# ENG-SP20008-R3-GEC-redlines.pdf Markup Summary

HOMESTEAD NORTH AT STERLING RANCH
EARLY GRADING & EROSION CONTROL PLAN

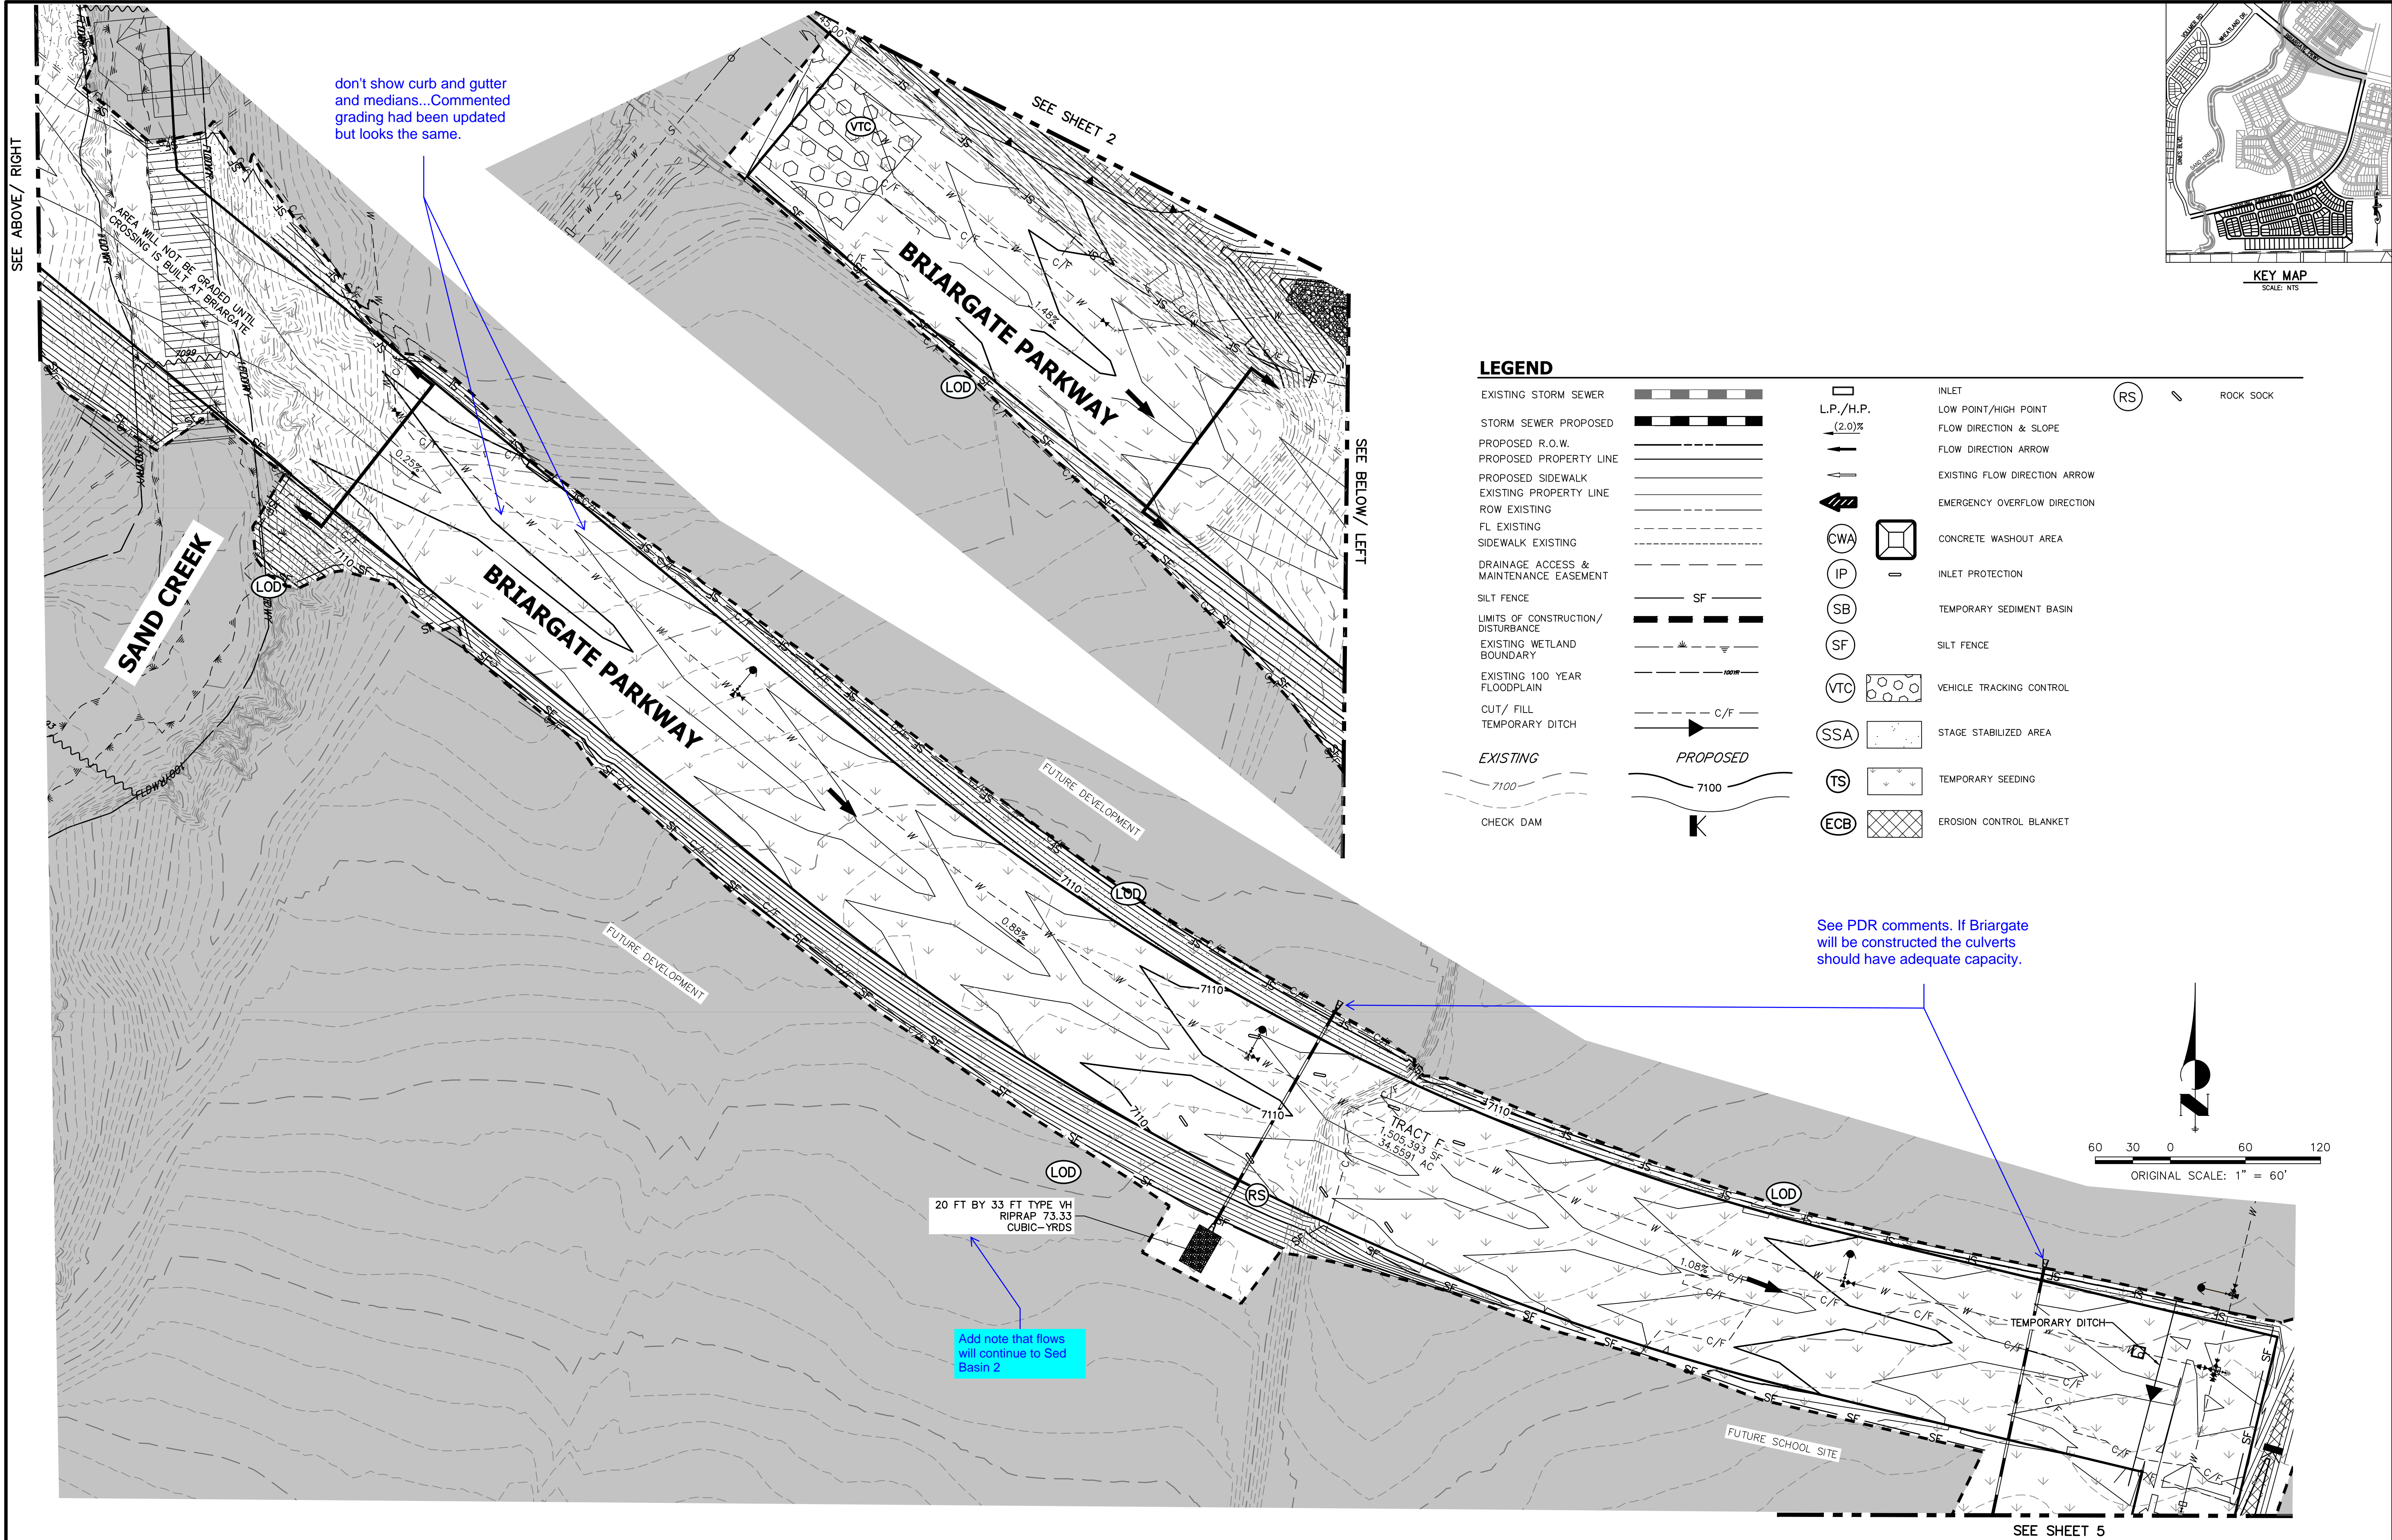
don't show curb and gutter and medians...
